Please ask for: Mrs D Johnson
Email: daun.johnson@arun.gov.uk
Telephone: 01903 737762
Our Ref: BN/65/22/PL
Your Ref:
Date: 6th June 2022

Application for Planning Permission

Development: Sever land and erection of 1 No bungalow with new vehicular access (resubmission of BN/14/22/PL). This application is a Departure from the Development Plan and is in CIL Zone 3 and is CIL Liable as new dwelling.
Location: Land At Rear Of Cedar End Eastergate Lane Eastergate PO20 3SJ

Proposed Site Plan
1:200

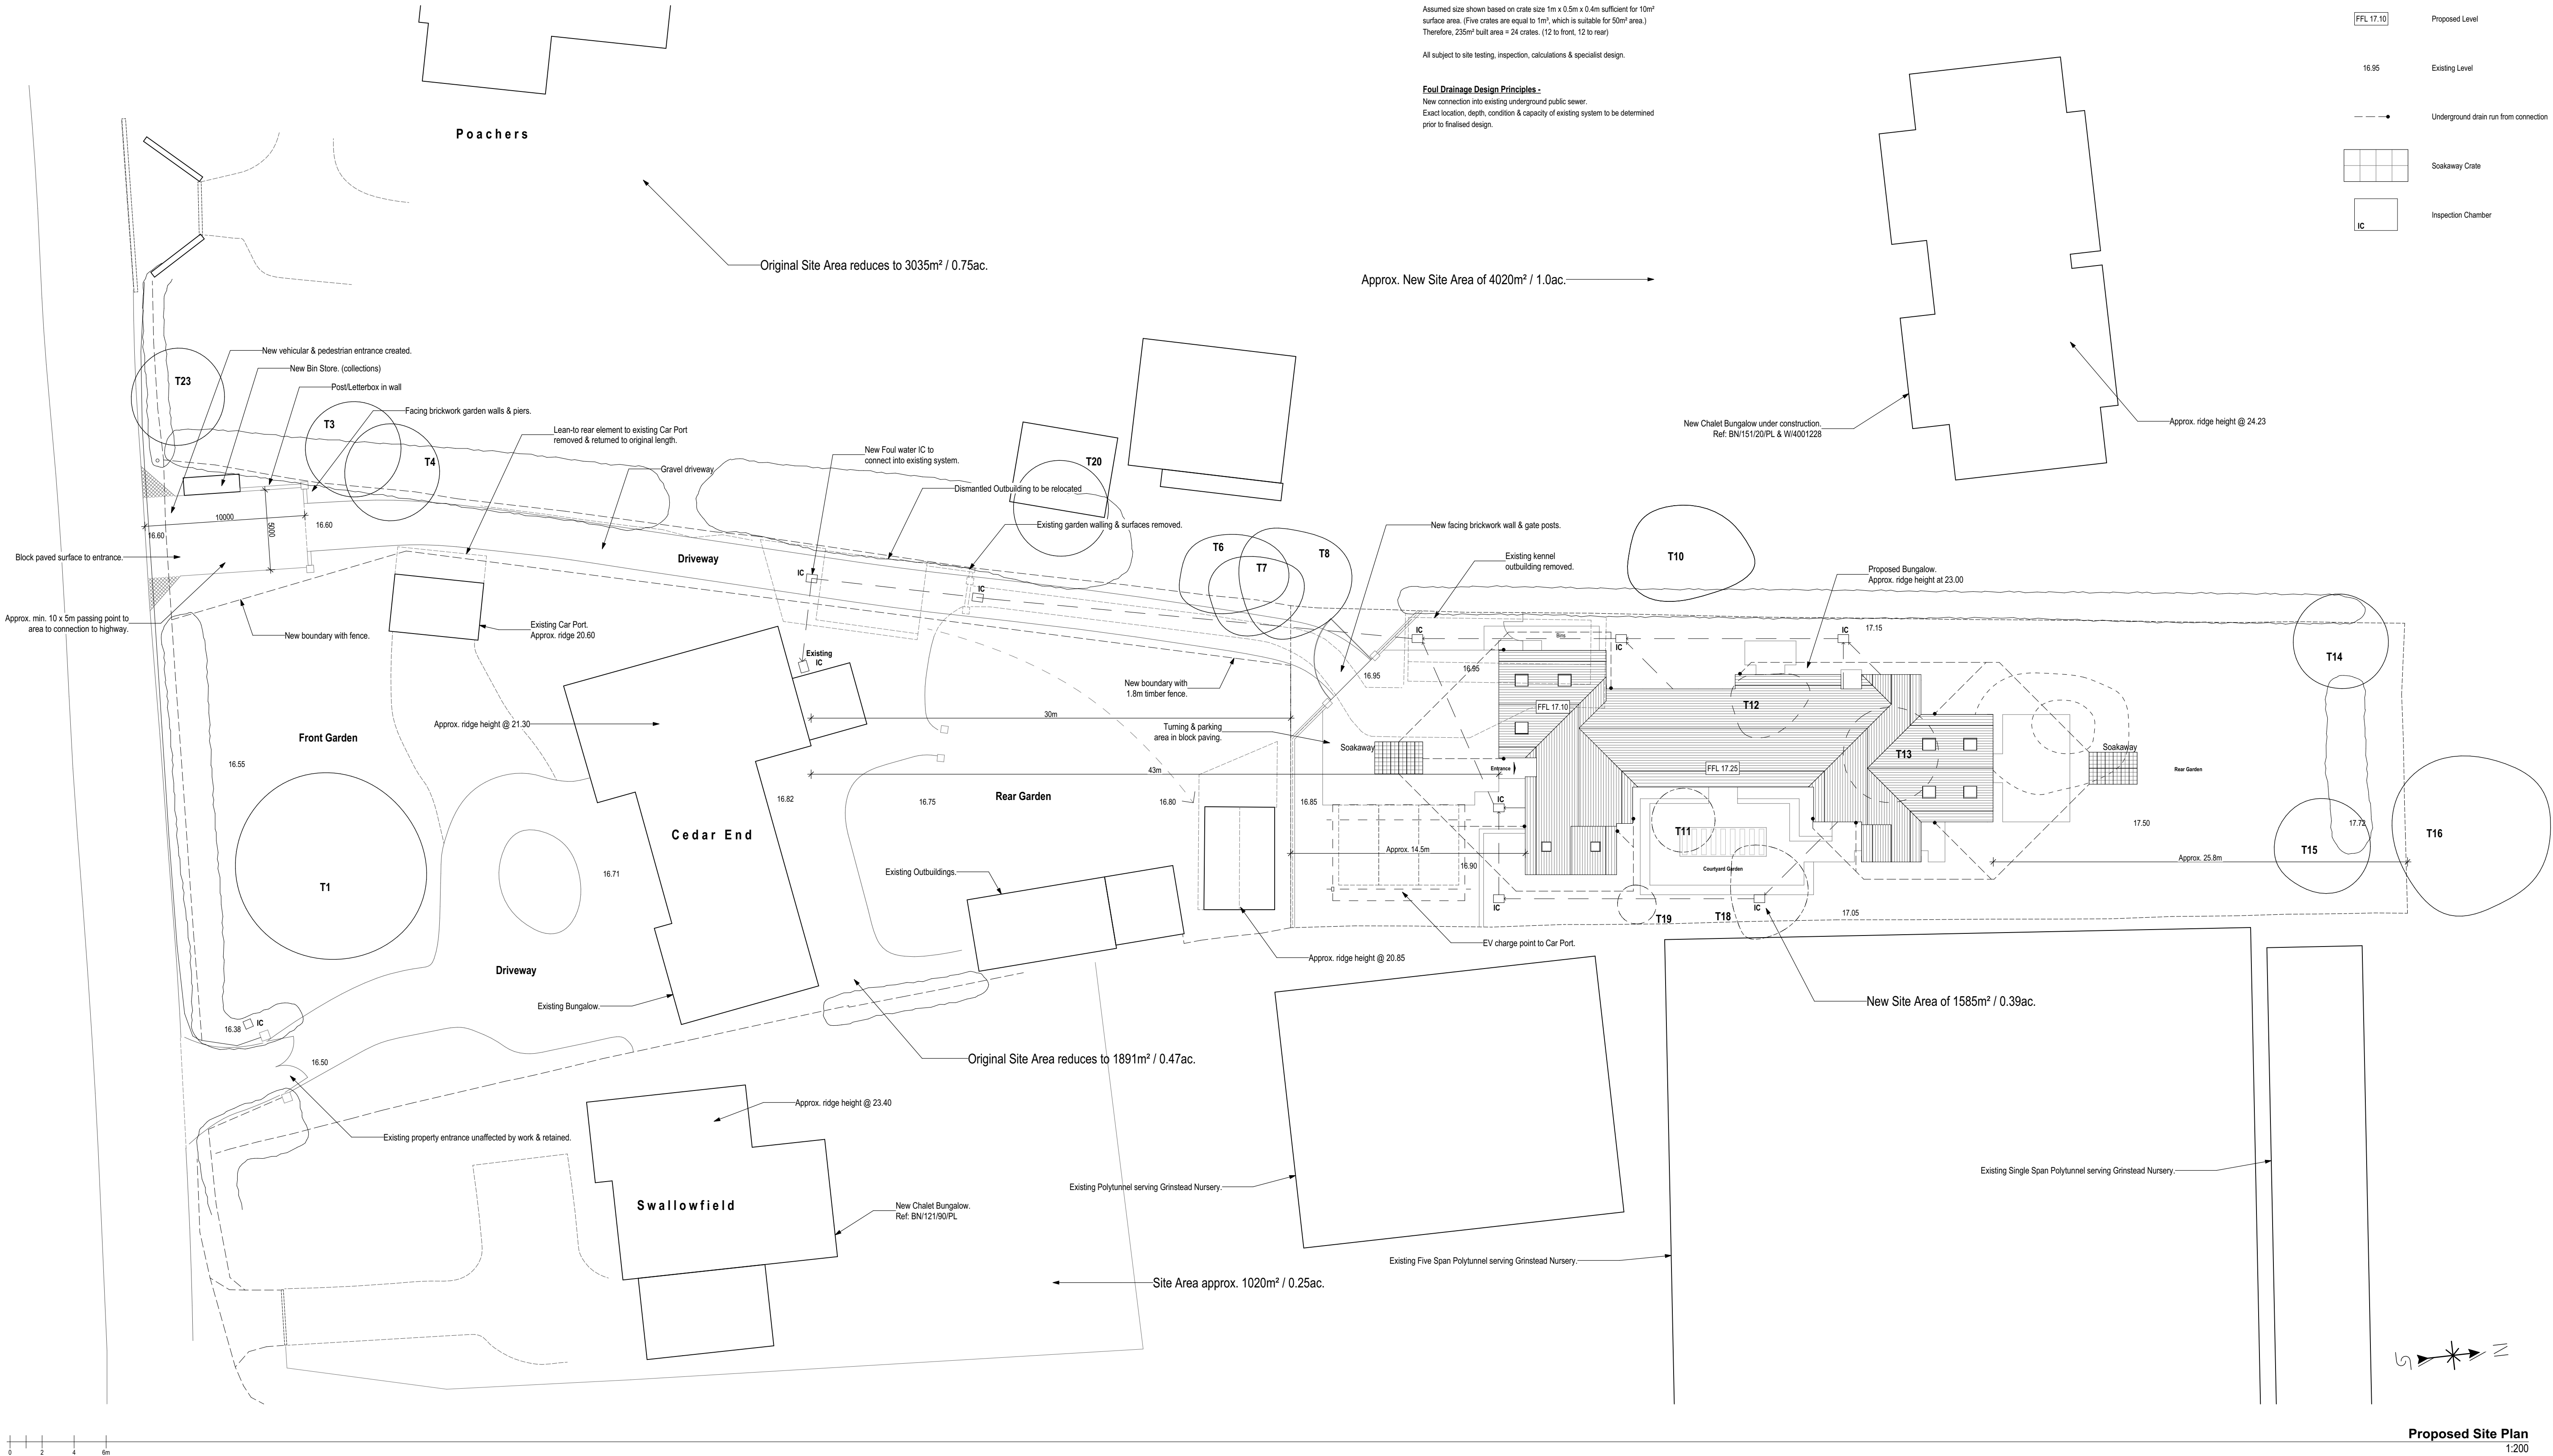
Please confirm how the foul water will be disposed.
